OUT19/12906

**Cadia Hill Tailings Completion - Modification 13 (06_0295)
EA Exhibition**

Simon Francis
Acting Manager, Assessments
DPIE Water – Strategic Relations
20 November 2019

Figure 2: Proposed Modification Layout

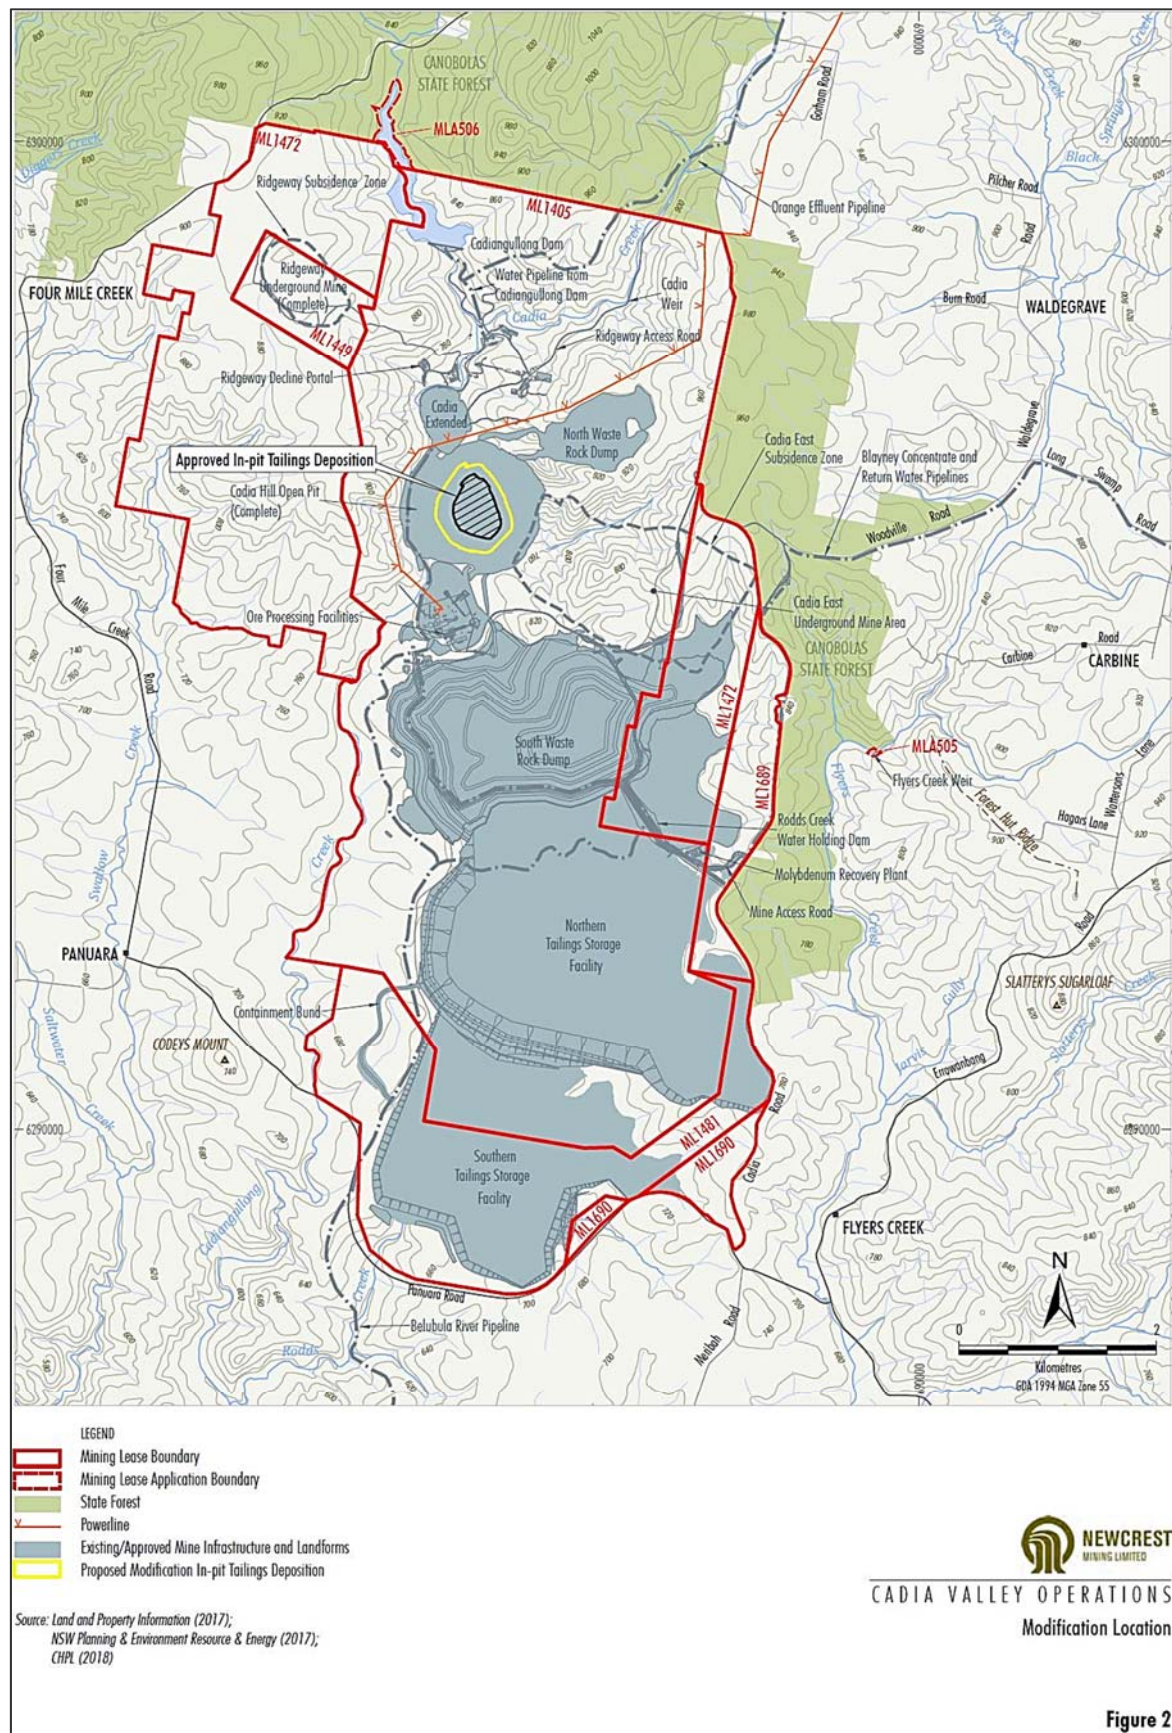
Insufficient information has been provided to quantify the change in groundwater and surface water take during operations and post closure due to the altered final pit and Cadia East void design. This information is required to confirm the variation in water take from water sources due to the modification and the adequacy of existing entitlements or where exemptions may apply. Also, insufficient information has been provided to quantify water take during construction and operation of the new ventilation adit, and the adequacy of existing entitlements.

- Provide a detailed water balance of the pit and Cadia East void to quantify the change in the groundwater inflows and surface water inflows in the relevant water sources during operations and post closure, and demonstrate the ability to hold the necessary entitlements.
- Quantify the water take during construction and operation of the new ventilation adit, and demonstrate the ability to hold the necessary entitlement.
